Black Forest Meadows Site Development Plan, PPR-21-49

Please accept the following comments from El Paso County Public Health (EPCPH) regarding the project referenced above:

Black Forest Meadows Outdoor Wedding Venue Concept Plan April 7, 2021

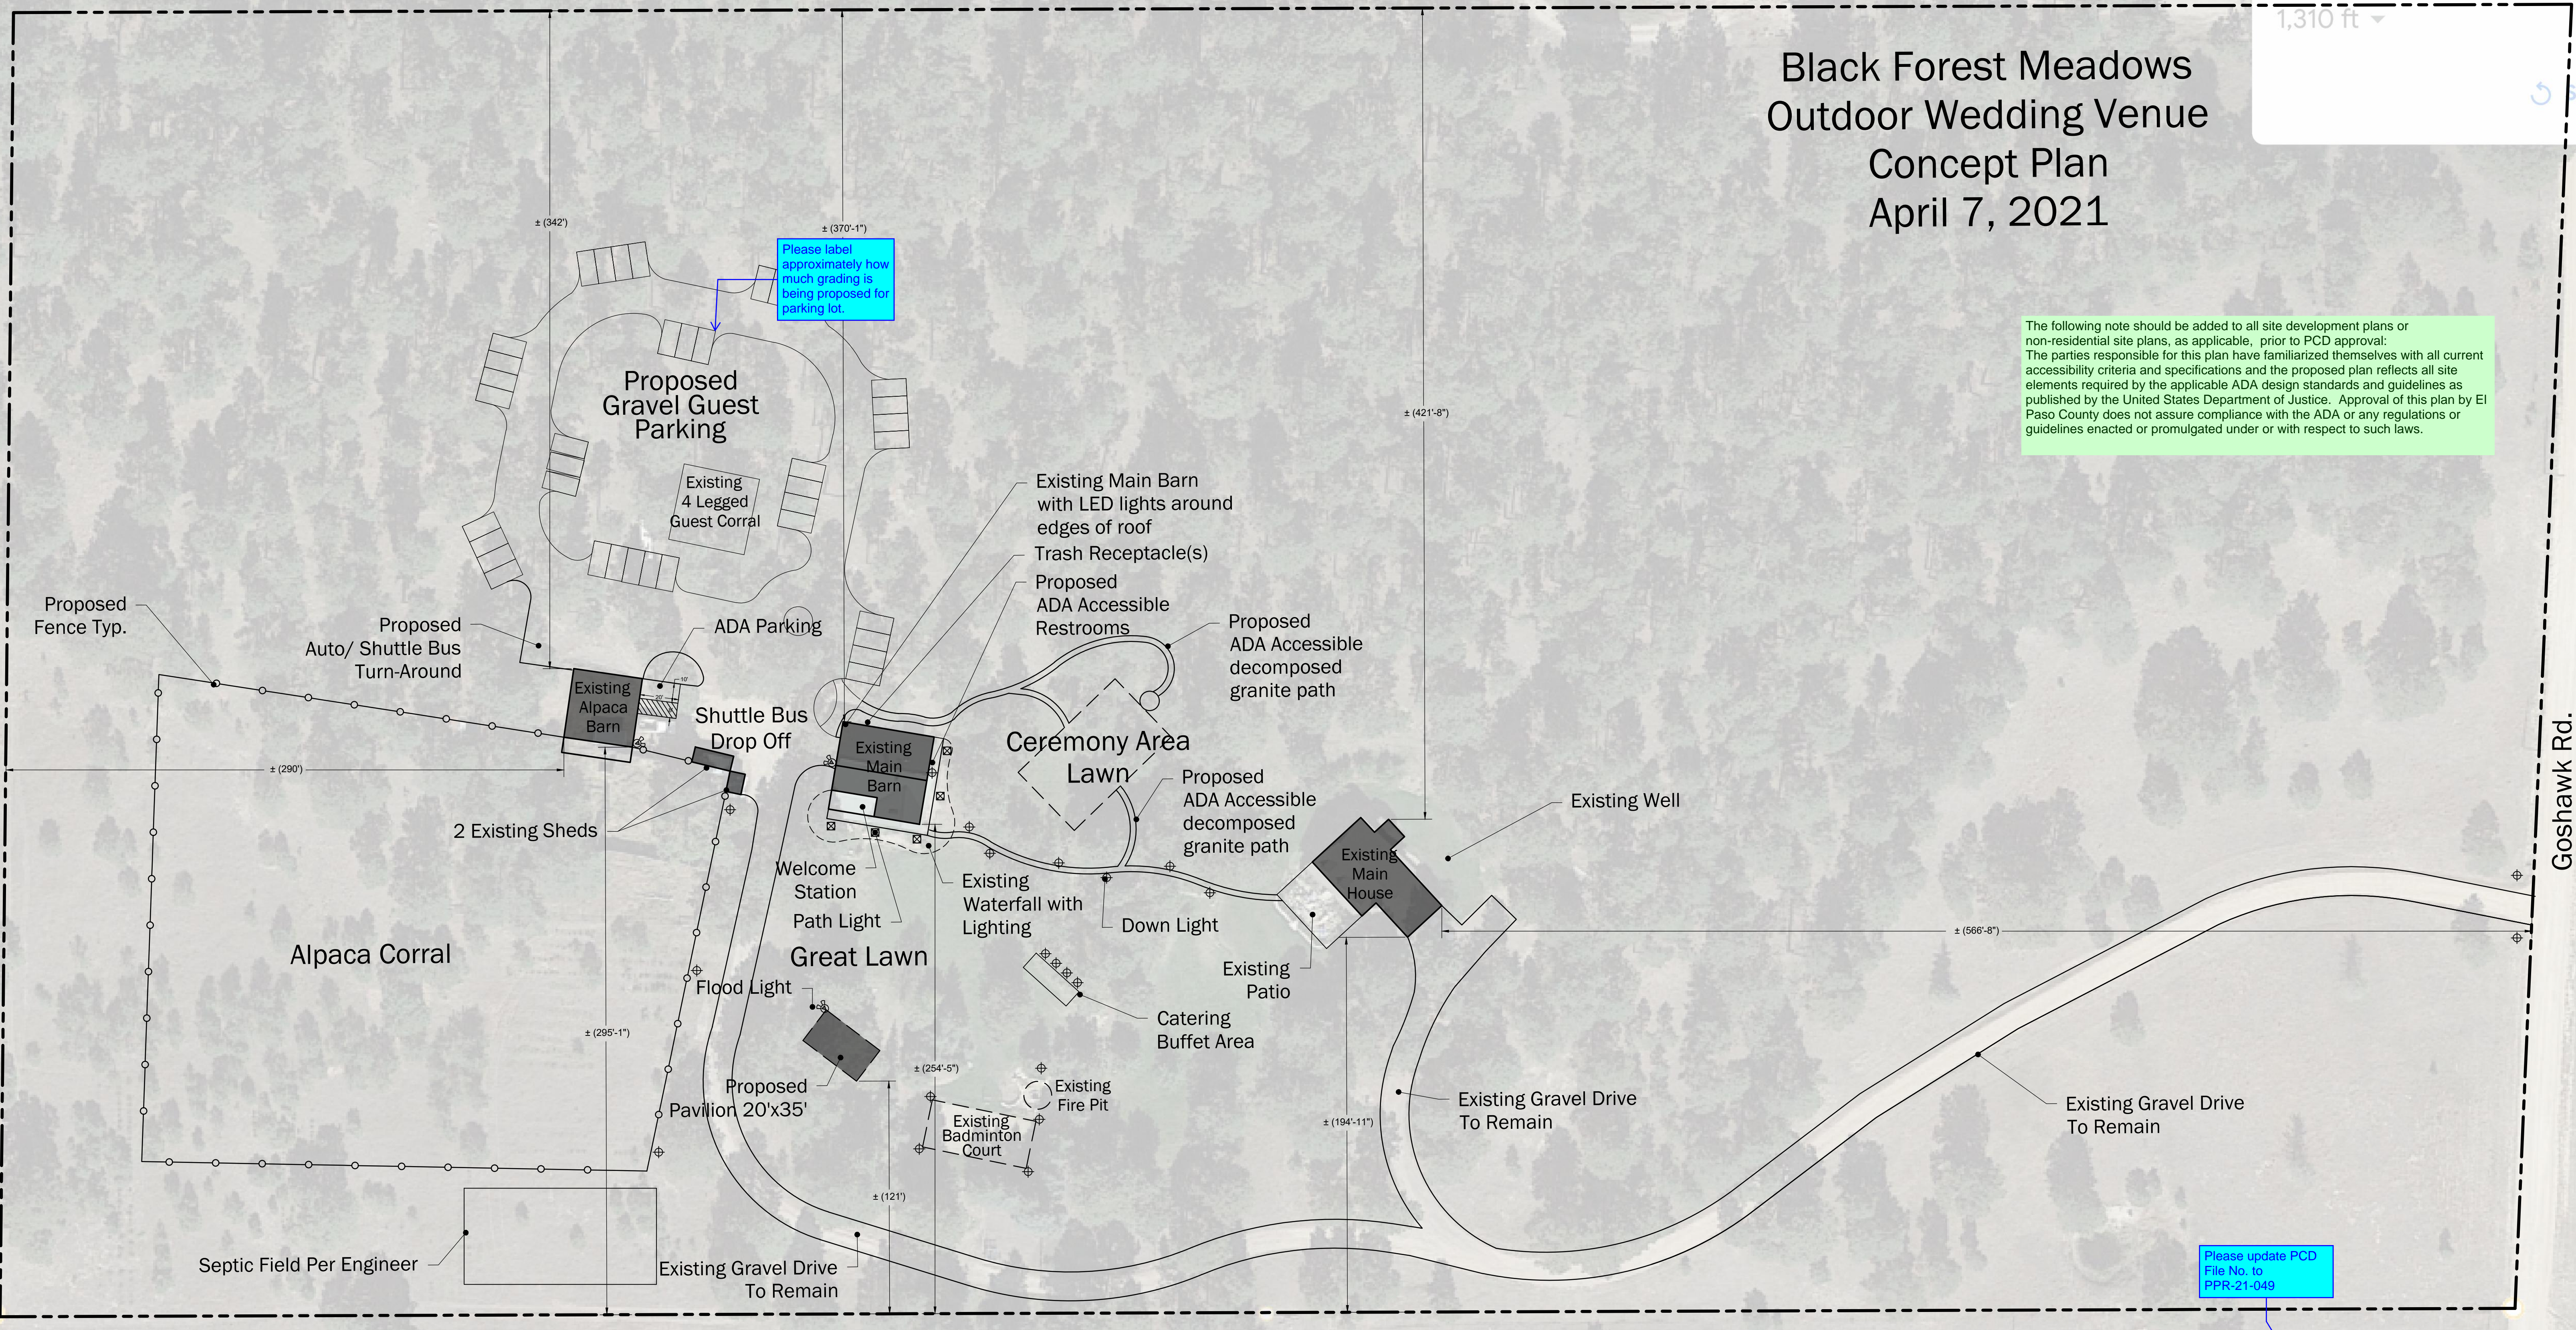
- Based on the Site Development Plan that shows where catered food will be served it appears there will not be food preparation on the site. Please confirm this with El Paso County Public Health.
